Re: Revisions of Wentworthville Public School SSDA Architectural Documentation

Fulton Trotter Architects have been engaged by the Department of Education to develop the design and documentation for the development application for the expansion of Wentworthville Public School, 70-100 Fullagar Road, Wentworthville, NSW.

Plan by Fulton Trotter Architects, Project No: 768WV01, Dwg No:SD-1001/Rev P8, Level 3, Dated 05/10/18

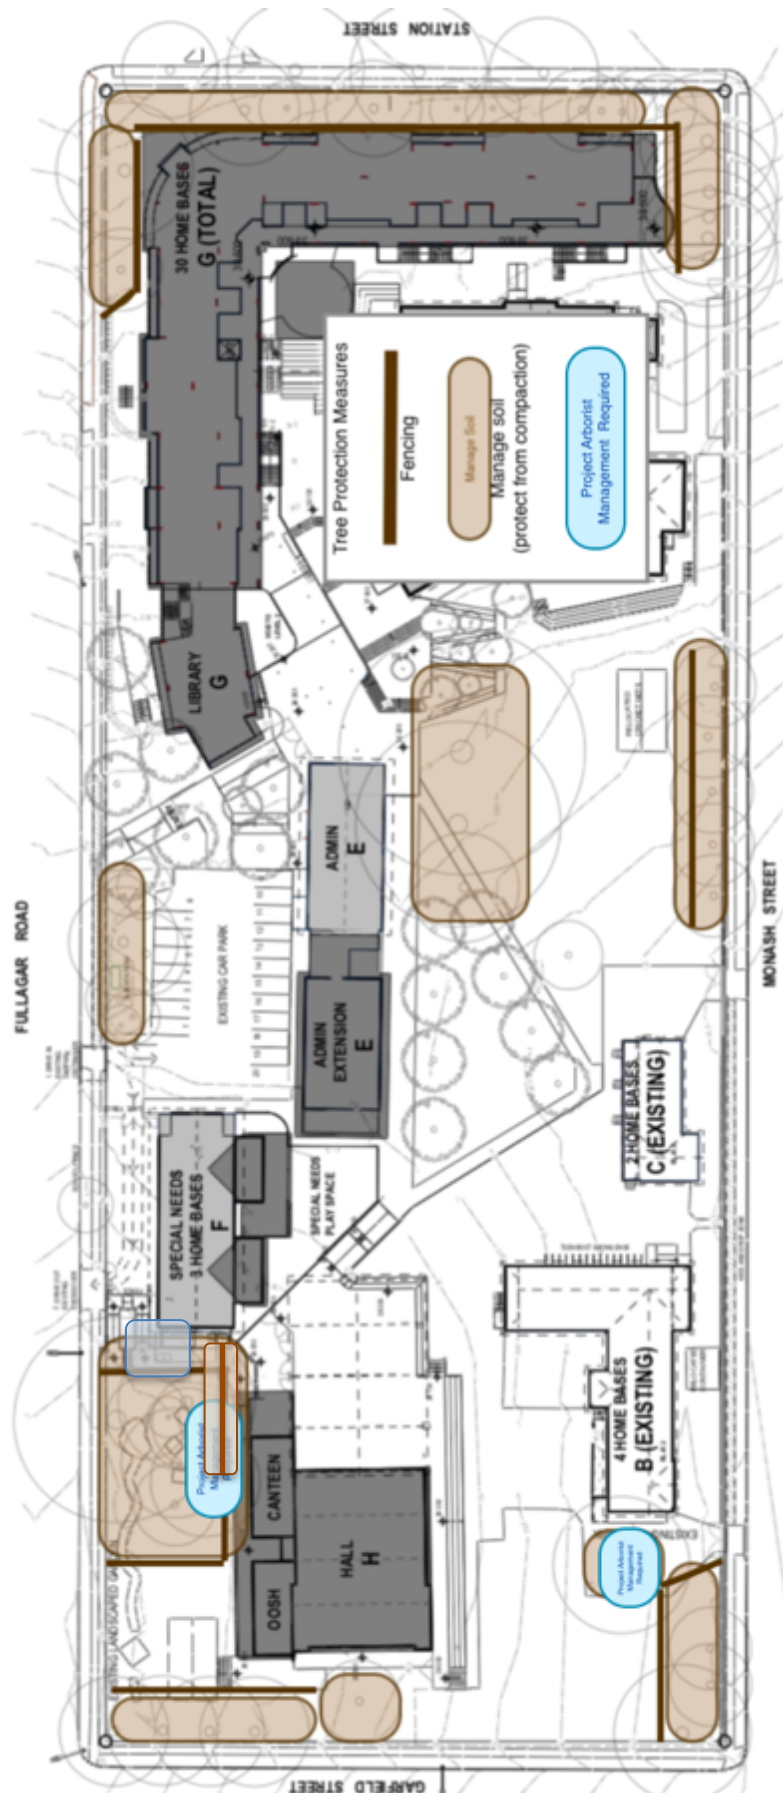
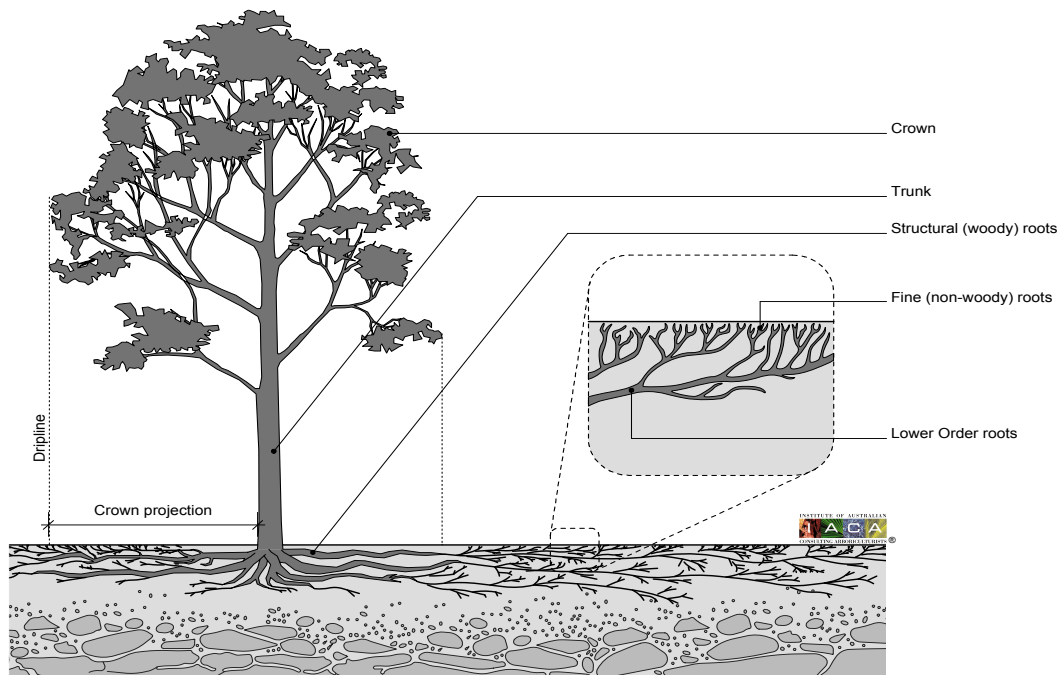
SD-1001 - LEVEL 3 - PROPOSED SITE PLAN _P15 is proposed to replace SD-1001 _P12

Proposed trees have been added to western and northern boundary.
